Colorado Springs, CO

Final Report - Corrections Required **Application No. DEPN-26-0013**

Description : Development Plan to establish internal roadways and lots. No end-users are proposed with this development plan application.

Document Filename : DP_V1_02-03-26

REVISIONS:
NO. DESCRIPTION
PROJECT NUMBER: 0219-05.03
SHEET 3 OF 6

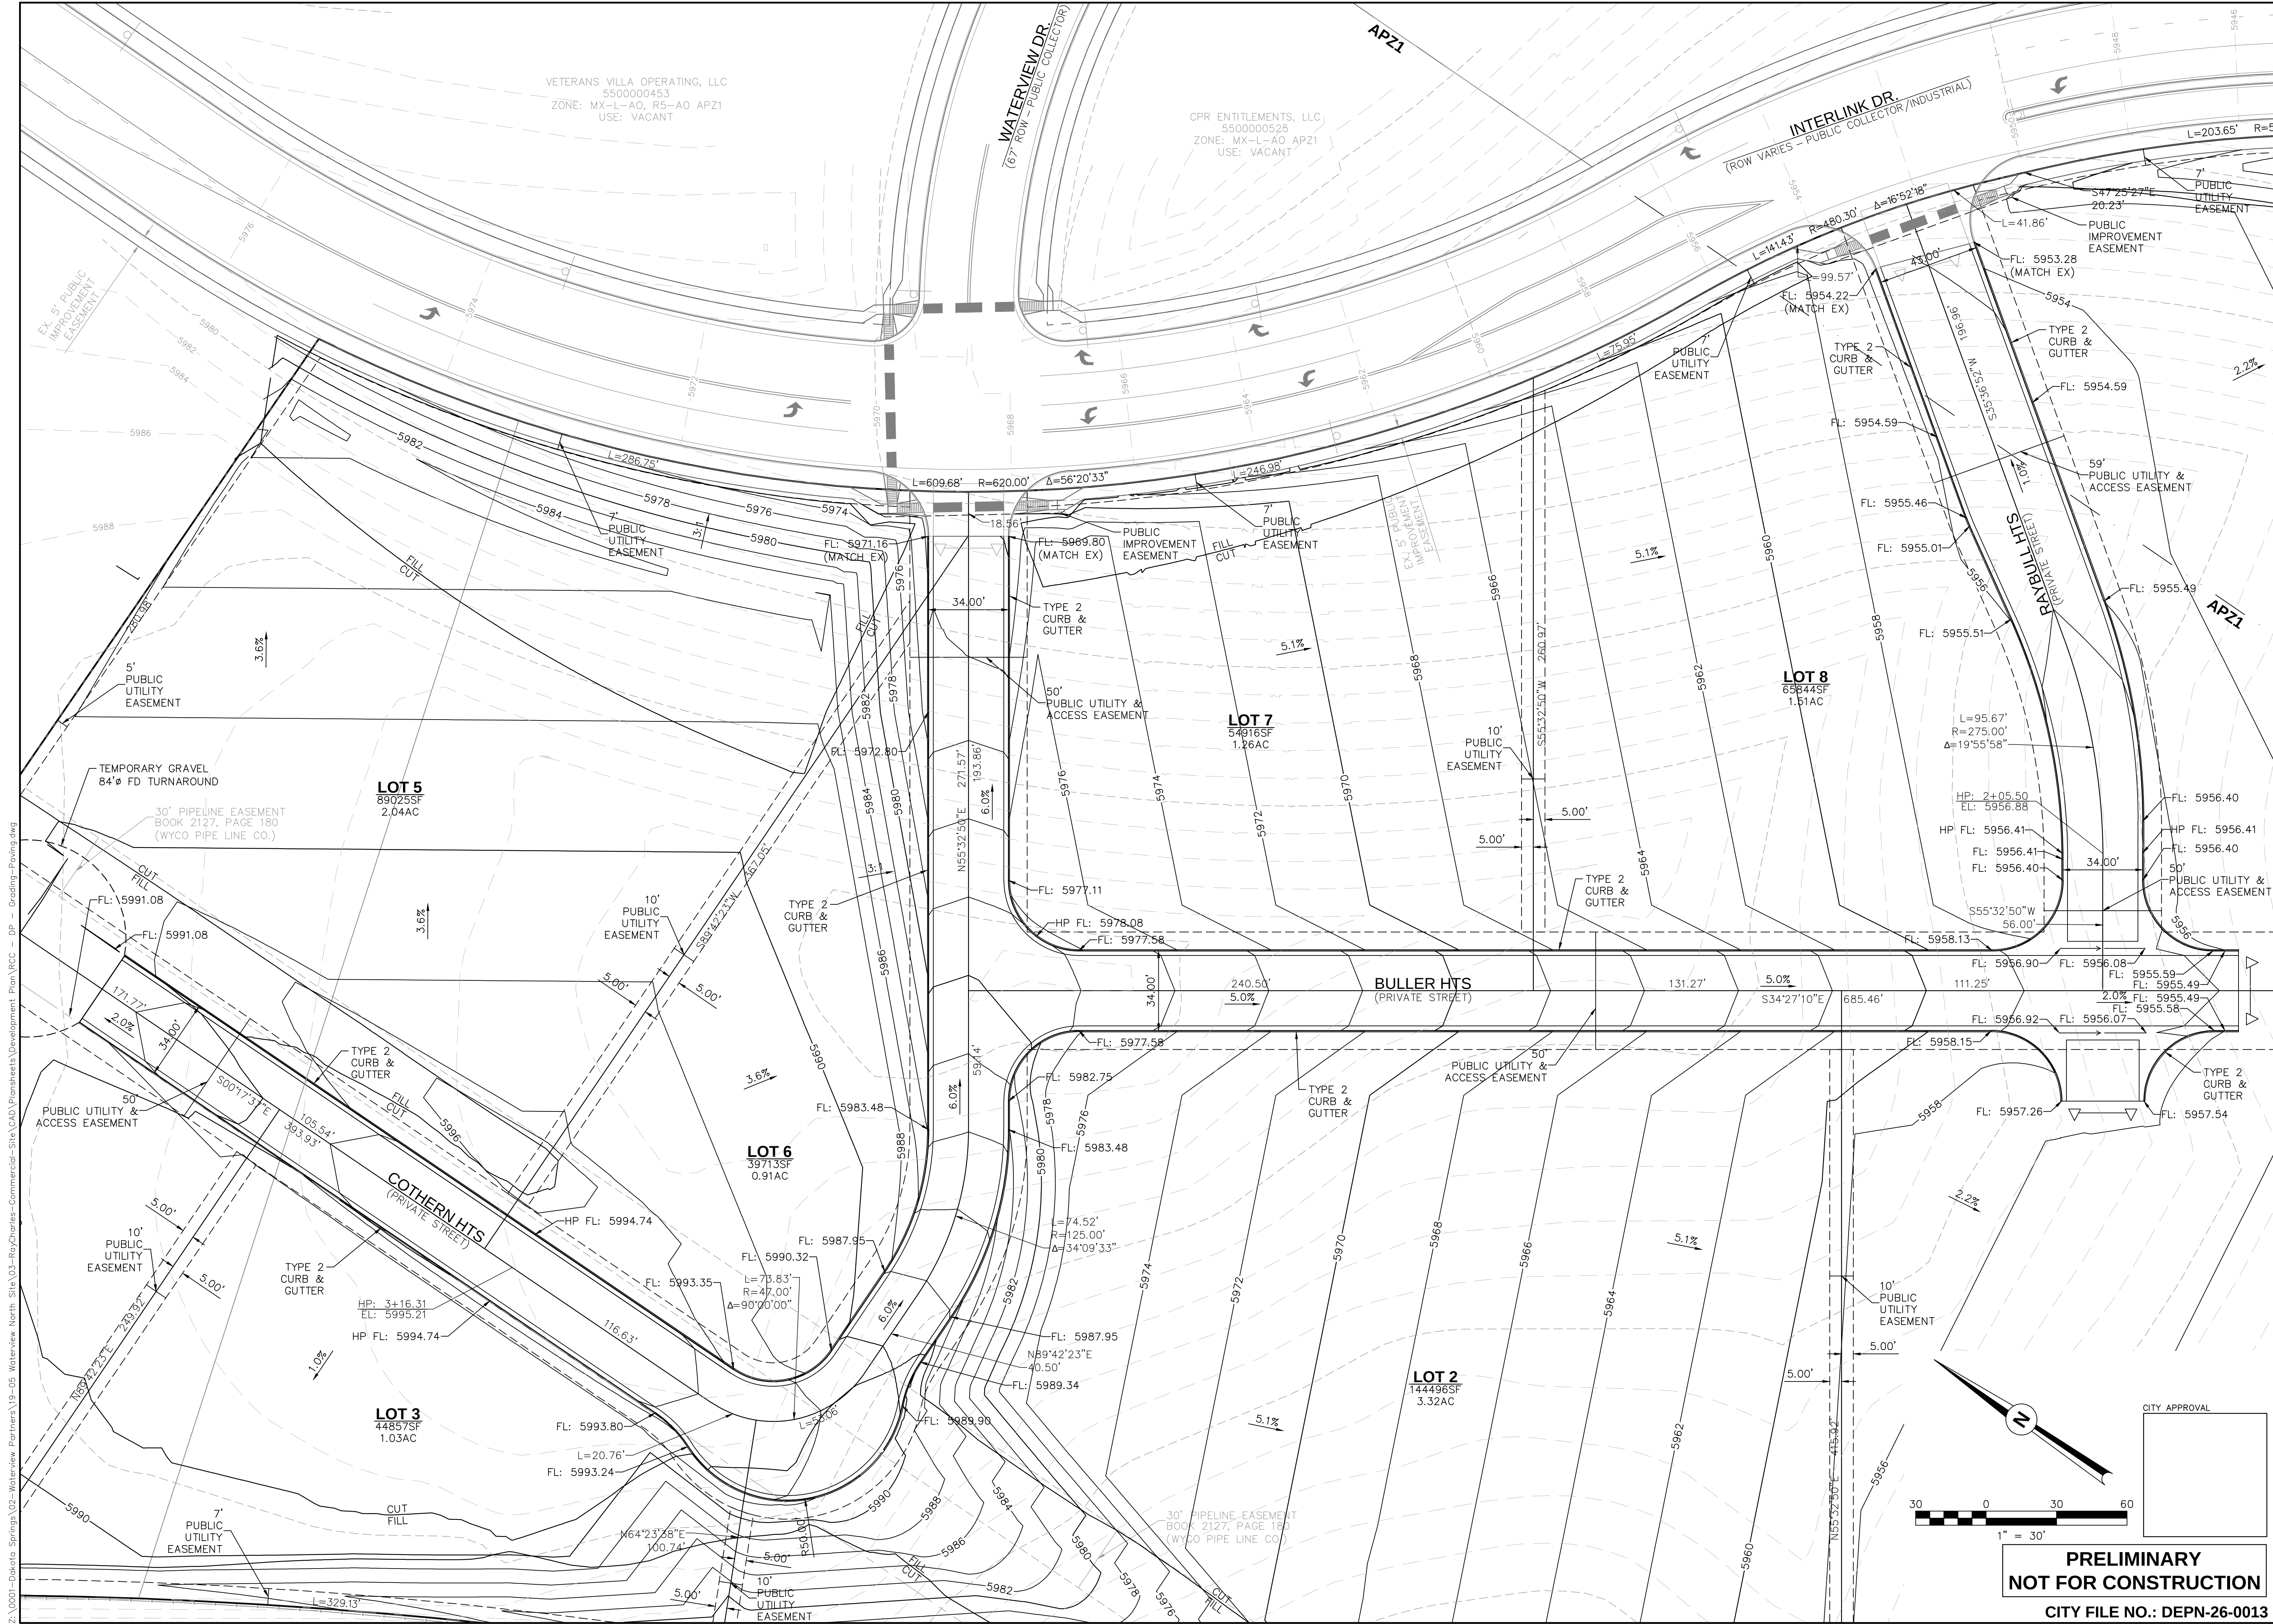
37	3	Sara Rivera : City Engineering - SWENT	The Four Step Process and detention requirements must be met for this site, as disturbance is greater than 1 acre. Show provisions for WQ/Detention or provide a note on the cover sheet stating the name and location of the existing facility that provides water quality and detention for the site. The note must include the full FDR name that designed the PCM, who prepared that report, and the approval date of the report. If this Site is a redevelopment, detention may not be required if the downstream drainage system is shown to have capacity for the proposed developed flow.
38	3	Sara Rivera : City Engineering - SWENT	Info Only: All swales will be required to have calculations provided in the FDR. The calculations must show the total depth of the swale, flow depth in the 100-year storm event, and the proposed lining material is appropriate for the velocity/shear stress in the 100-year storm event. If the swale is 1.5-feet deep or greater, it must be shown that 1-ft of freeboard is provided in the 100-year storm event.

Comment ID	Page Reference	Reviewer : Department	Review Comments
39	3	Sara Rivera : City Engineering - SWENT	Info Only: The proposed project disturbs greater than an acre and will therefore require a separate Grading and Erosion Control Plan (GEC) and the City's Stormwater Management Plan (CSWMP). These plans will need to meet the requirements listed in the City's Stormwater Construction Manual (SCM) and should be submitted via ProjectDox to the Stormwater Enterprise for review and approval. Construction details for Planned Infiltration Areas must be included in the final phase of the GEC Plan. Assurances in the amount of the total cost of the temporary construction control measures (CCMs) will be required prior to the approval of the GEC. Once the GEC & CSWMP are approved, then the applicant must apply for a City GEC Permit by completing and submitting the GEC Permit application and paying the associated fee in Accela.

41	3	Sara Rivera : City Engineering - SWENT	Please show and label all private and public easements as applicable on all sheets.
42	4	Sara Rivera : City Engineering - SWENT	Info Only: The City of Colorado Springs (City) Public Works Department issued updated standard details for inlets on July 8th, 2024. The updated inlet details are available here: Link . All proposed inlets in the City of Colorado Springs must conform to these updated inlet details. Please note that these five (5) new City standard inlet types are similar to other previously acceptable inlet types, as can be seen in SWENT's May 2025 Policy Clarification, "Hydraulic Modeling for Colorado Springs Standard Inlets" available here: Link .
43	4	Sara Rivera : City Engineering - SWENT	All proposed inlets must meet one of the five (5) new / updated City standard inlet types. See related Info Only comment for more information.
44	4	Sara Rivera : City Engineering - SWENT	Green Infrastructure: the Planned Infiltration Area (PIAs) need to be delineated with a line or a hatch. There must be a leader calling it out as a "Planned Infiltration Area" or it must be included in the legend as "Planned Infiltration Area.". This must match what is being shown in the PDR/FDR. The PIAs must be shown on the Landscape Plans, Grading Plans, and Utility Plans. Please see the revised Development Plan checklist for further clarification: Link

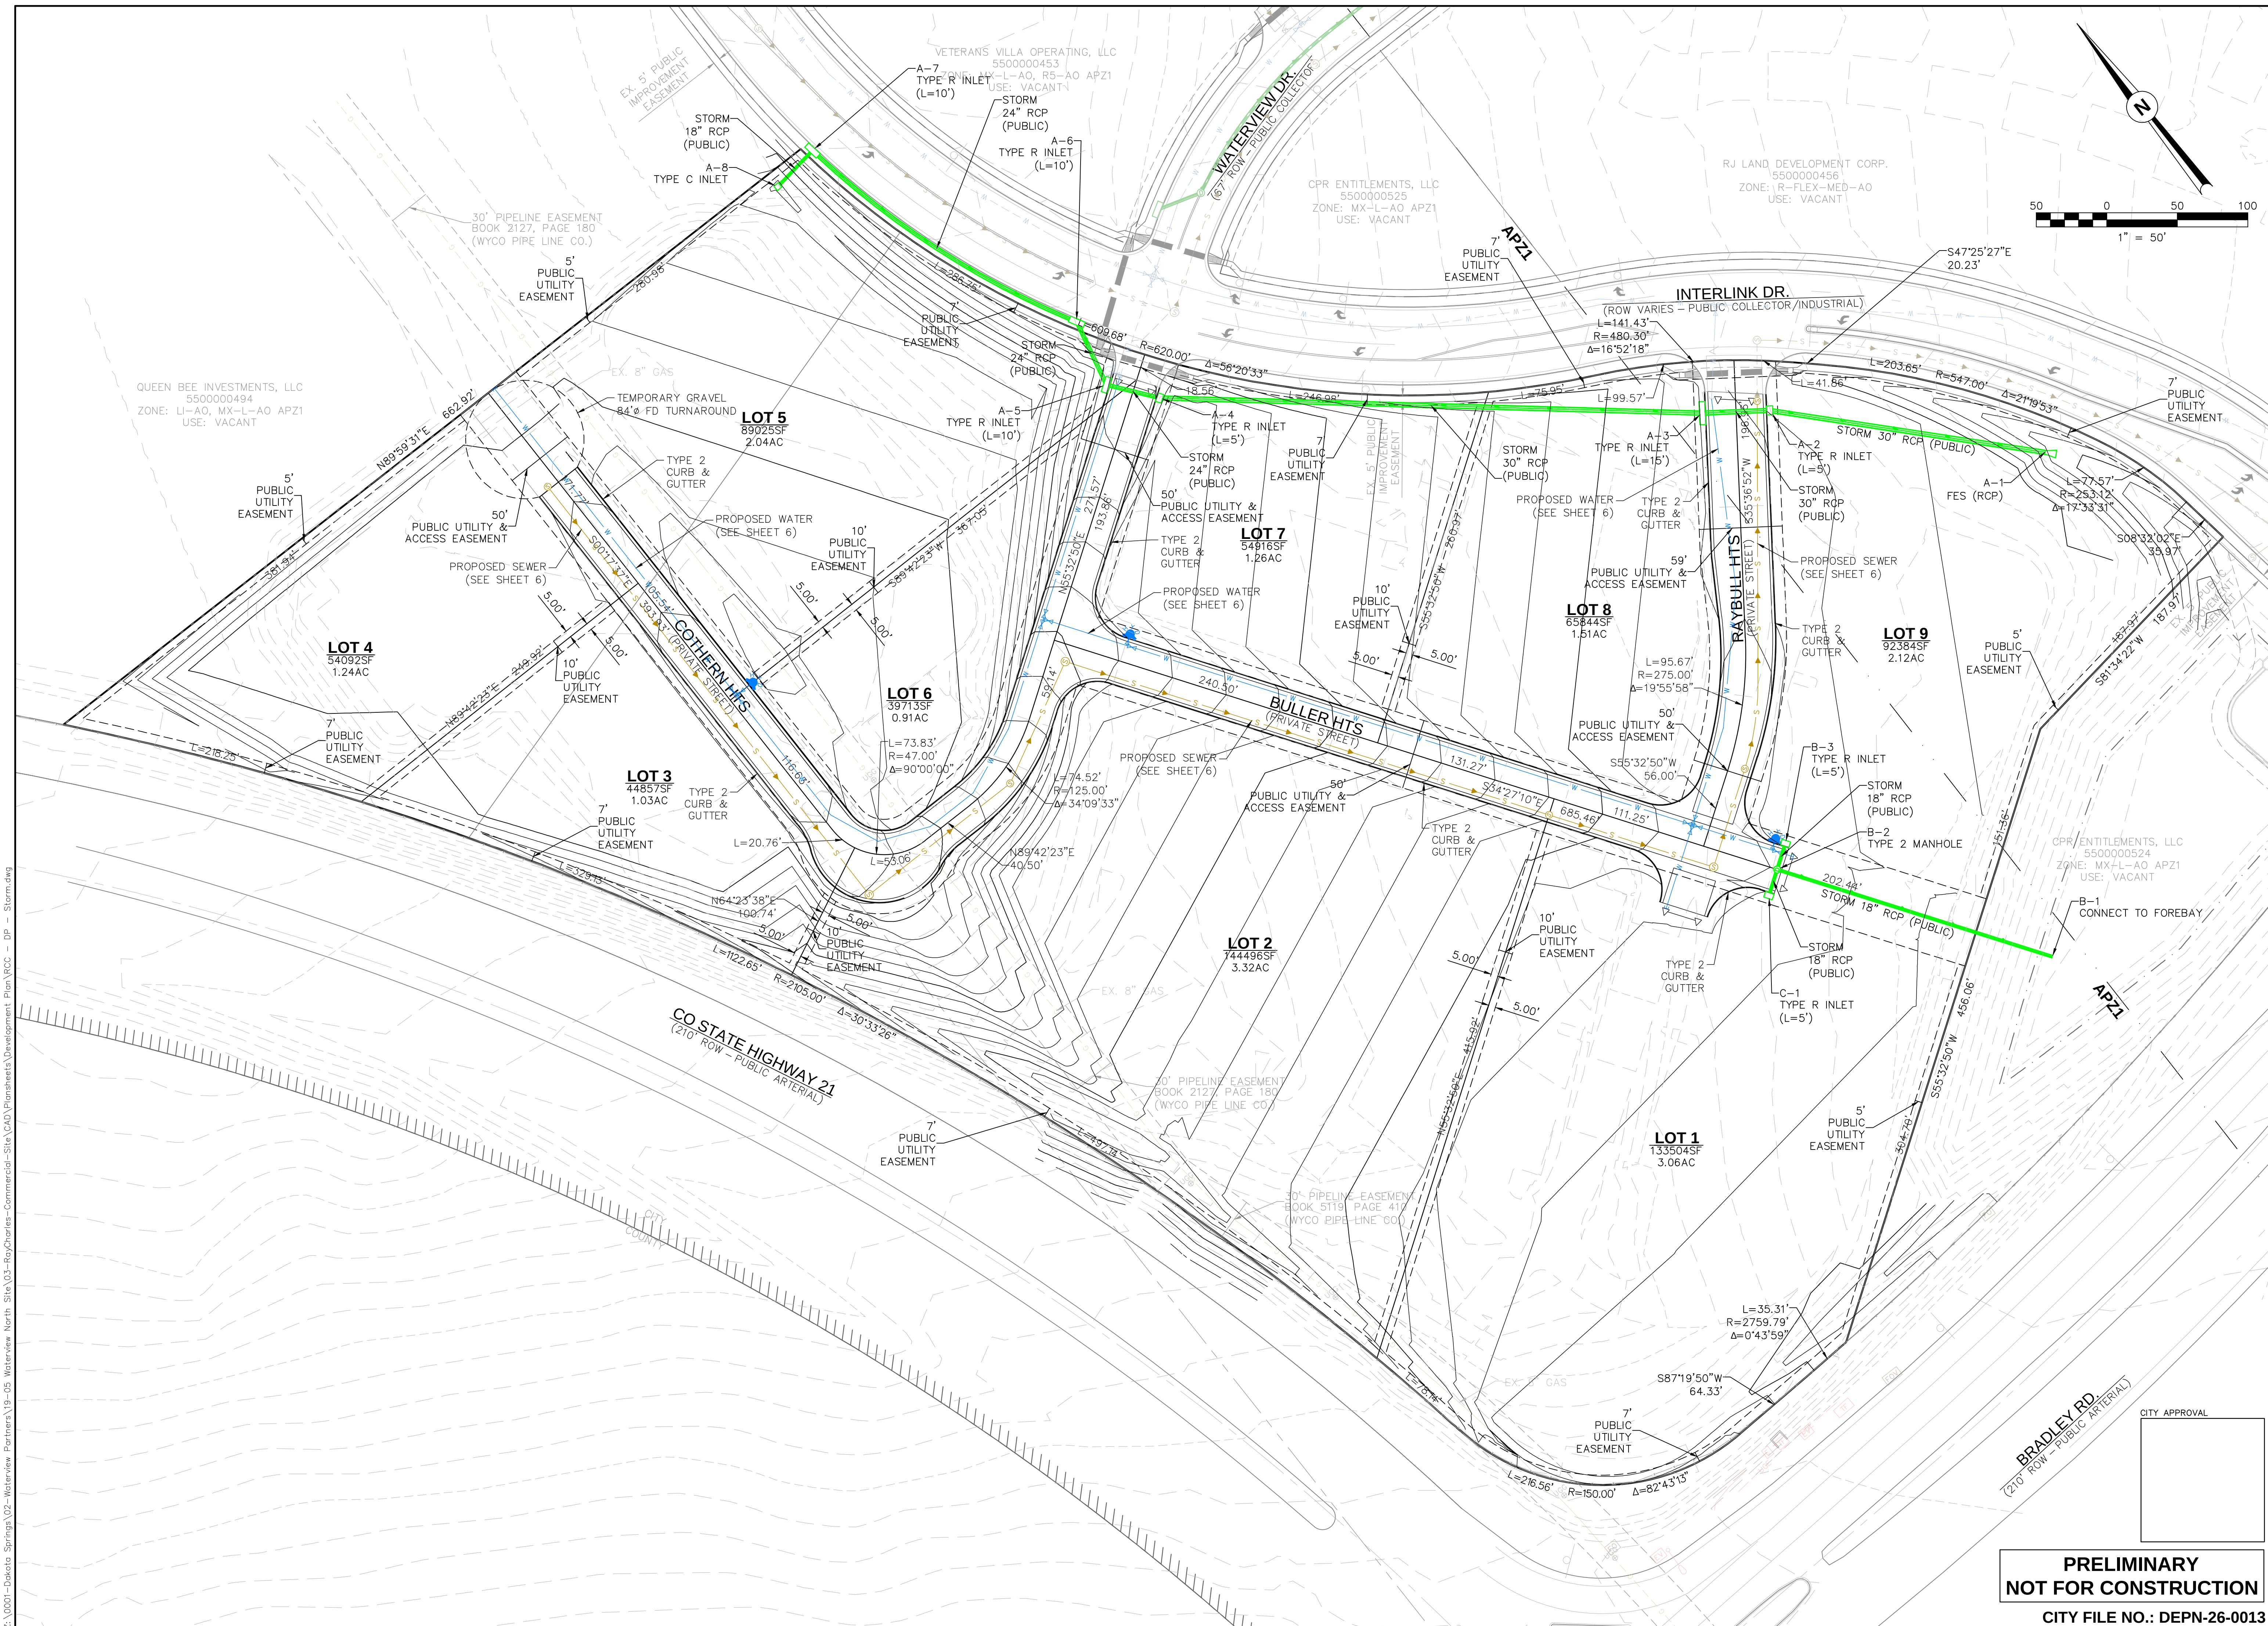
45	4	Sara Rivera : City Engineering - SWENT	Label all existing and proposed drainage infrastructure with size and ownership (private or public).
46	4	Sara Rivera : City Engineering - SWENT	Info Only: Construction Plans for the proposed storm sewer larger than 12" will need to be submitted to Engineering Development Review and Stormwater Enterprise for review and approval prior to construction.
40	3	Sara Rivera : City Engineering - SWENT	Add a note that all private to public storm sewer connections must be inspected by an Engineering Development Review Inspector.
47	5	Sara Rivera : City Engineering - SWENT	The offsite disturbance associated with utility installations must be included in the total disturbed area. In the FDR, areas of disturbance for offsite utility installation can be excluded from the total disturbed area as it applies to the Four Step Process, but this exclusion must be clearly documented. Please reach out to the Lead Reviewer if there are questions on how to show this. For the GEC and CWMP this disturbed area must be shown and included. This area cannot be excluded in these plans/reports.
